WEST SUSSEX COUNTY COUNCIL
LOCAL DEVELOPMENT SERVICES CONSULTATION

SUBJECT: LU/166/08/A - 1 x internally illuminated fascia sign

9, East Street, Littlehampton, West Sussex

PROPOSED ELEVATION

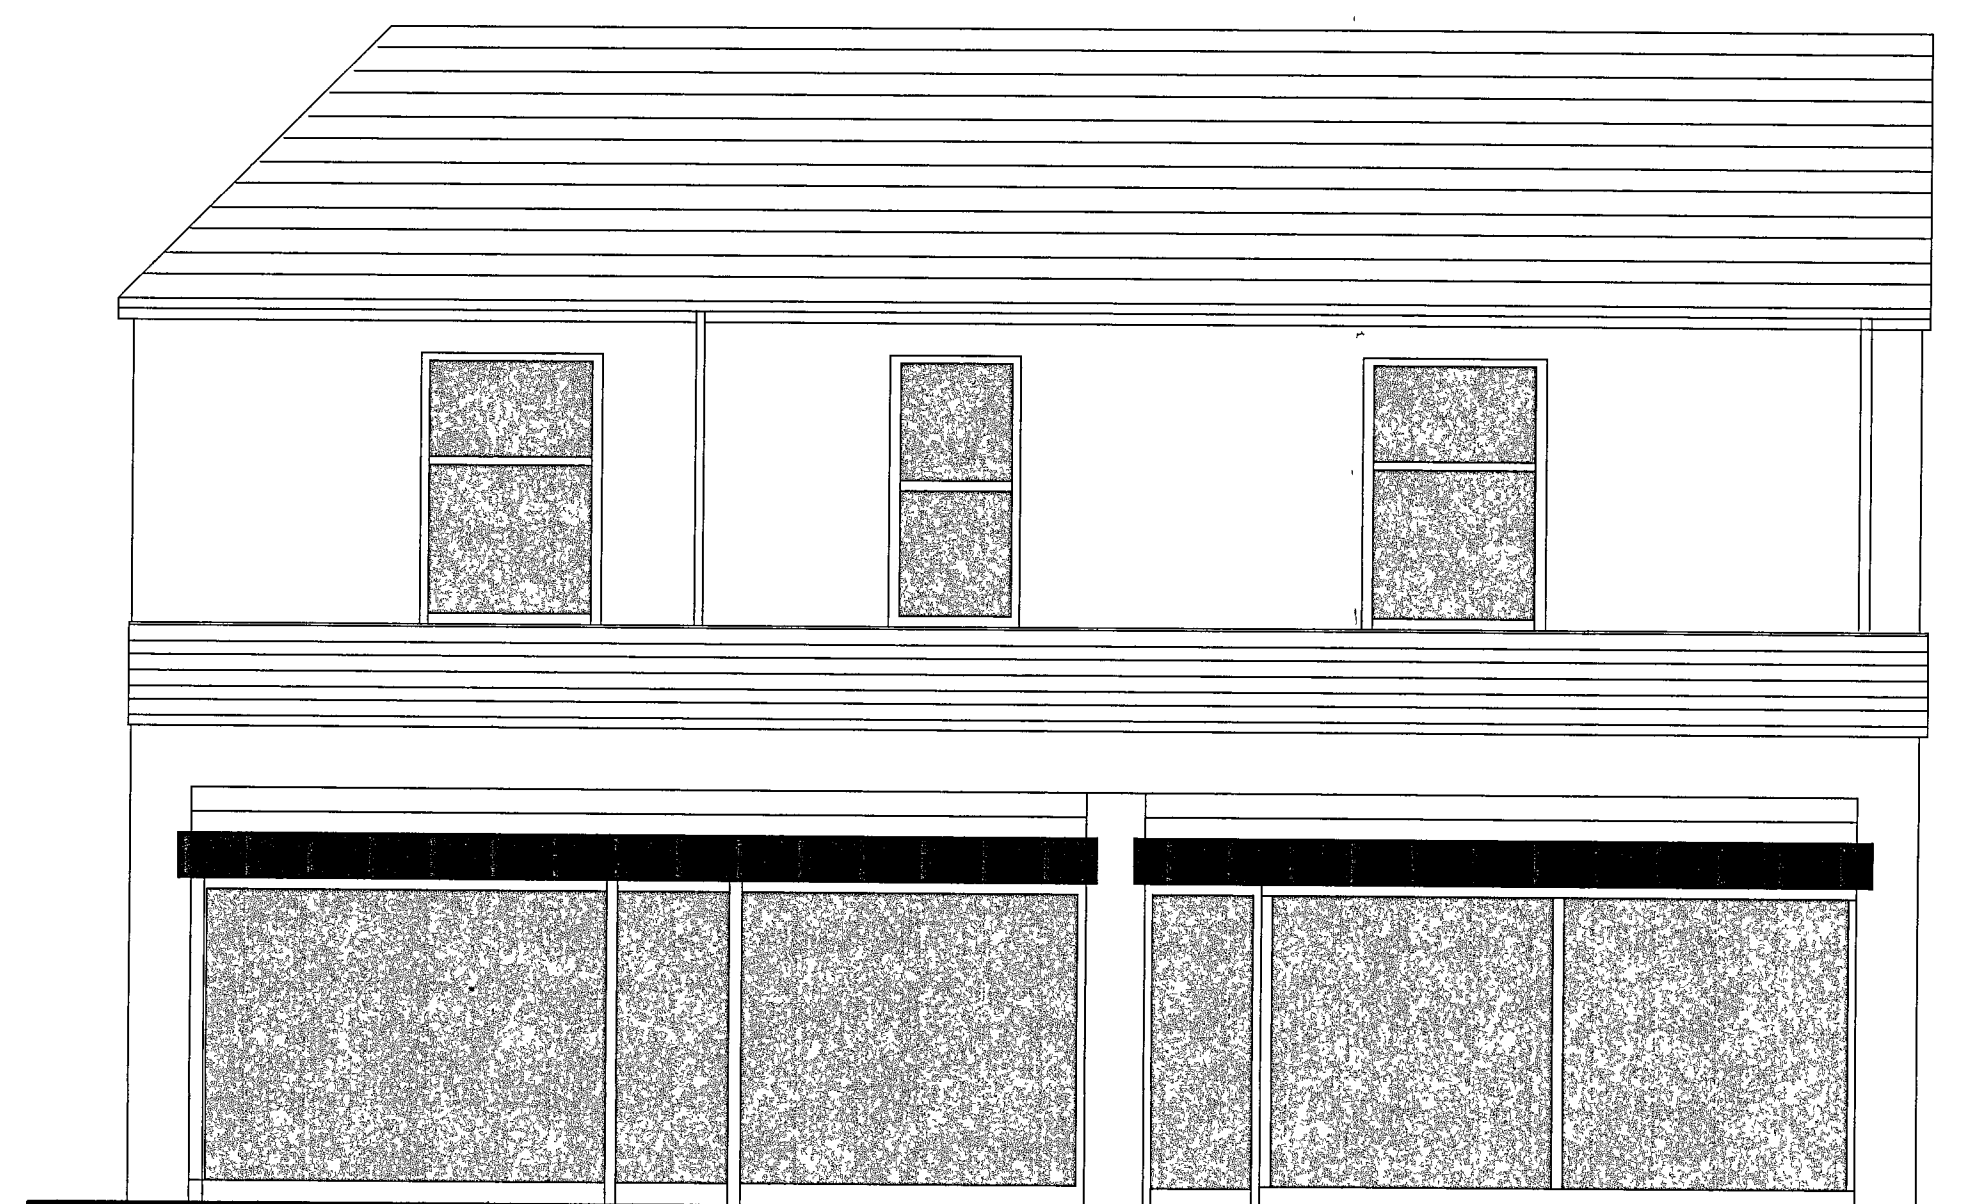
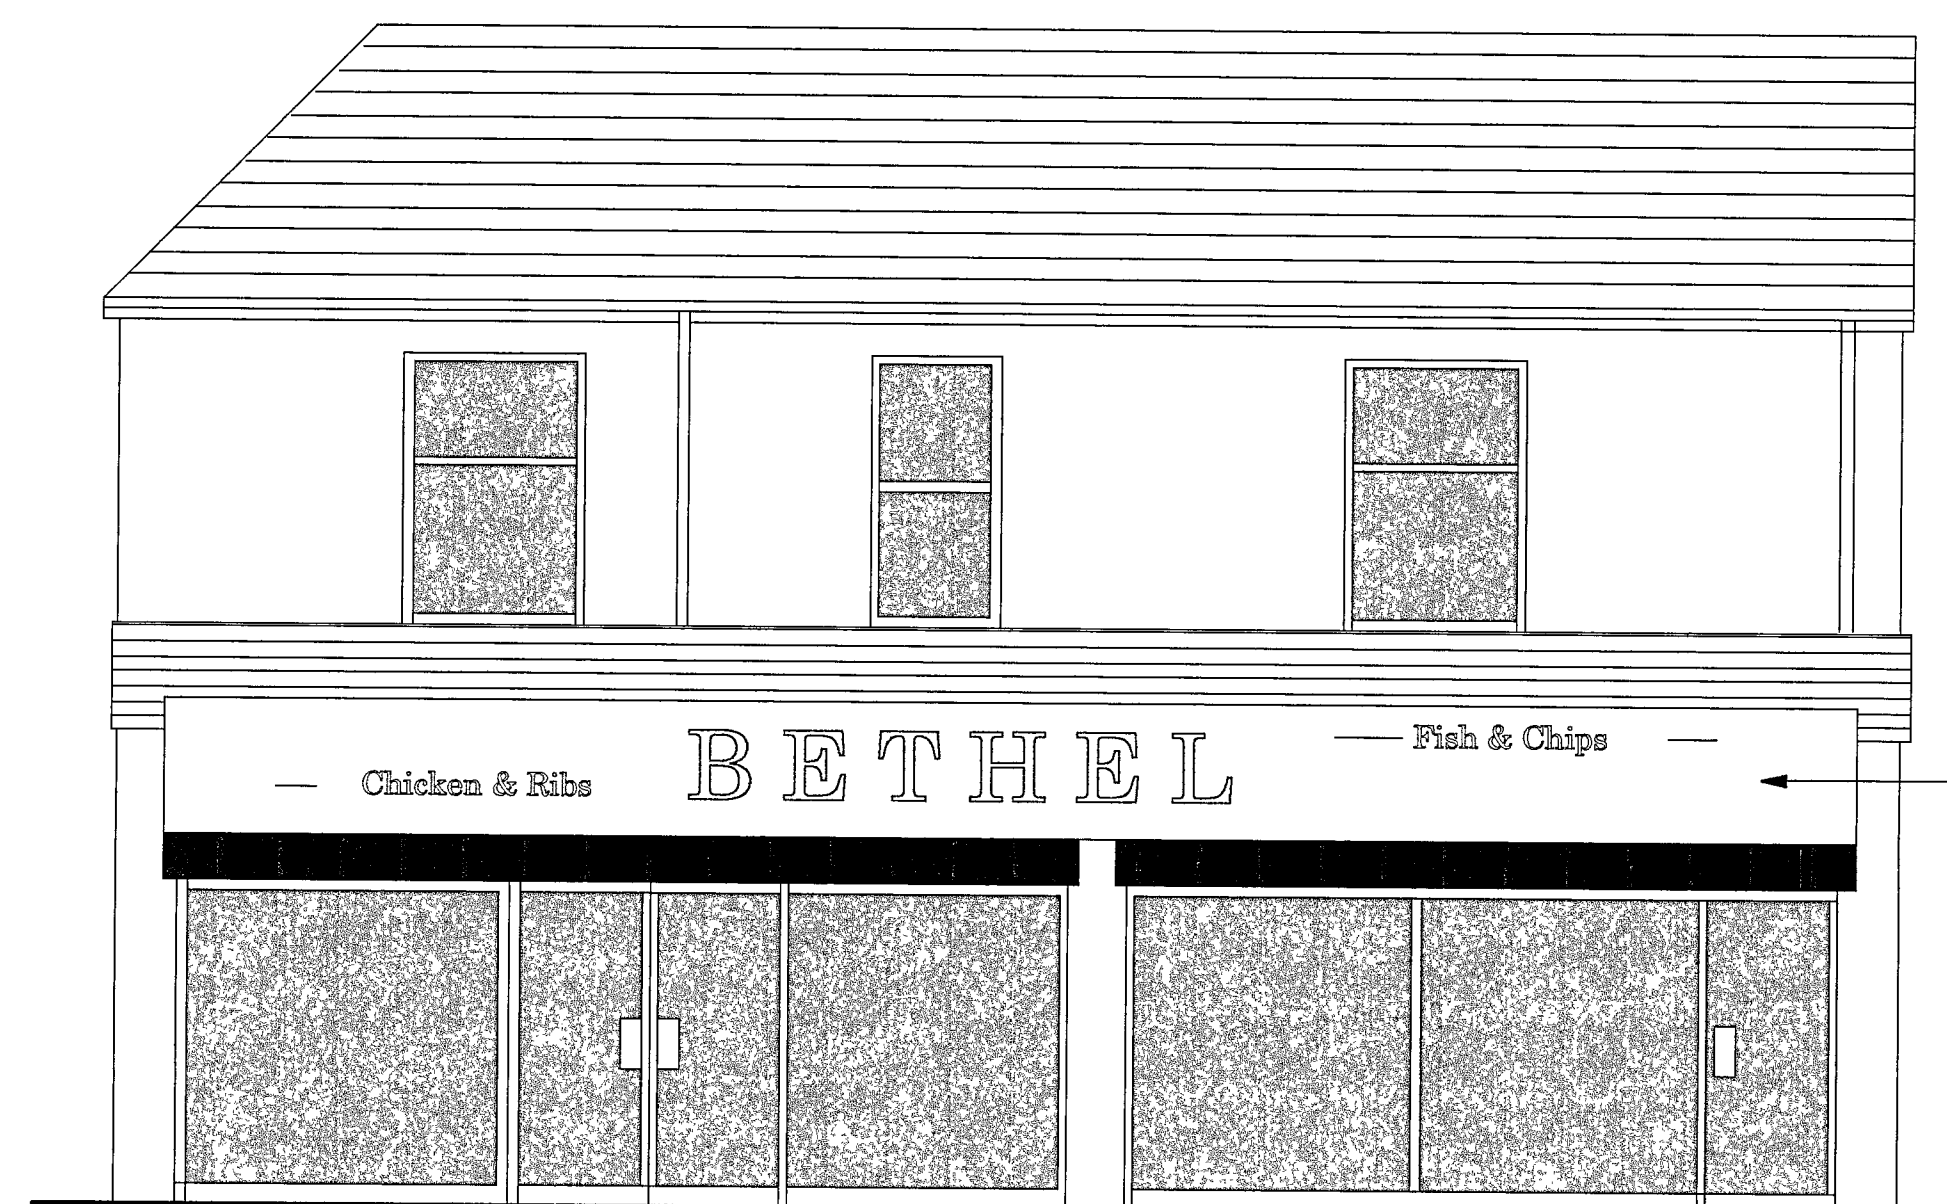
The proposed sign does not raise any significant highway safety concerns. The fascia sign is not thought to be in such a position as to restrict visibility, cause a hazard to pedestrians or distract drivers. As a fascia sign, the sign will not be on the publicly maintained highway.
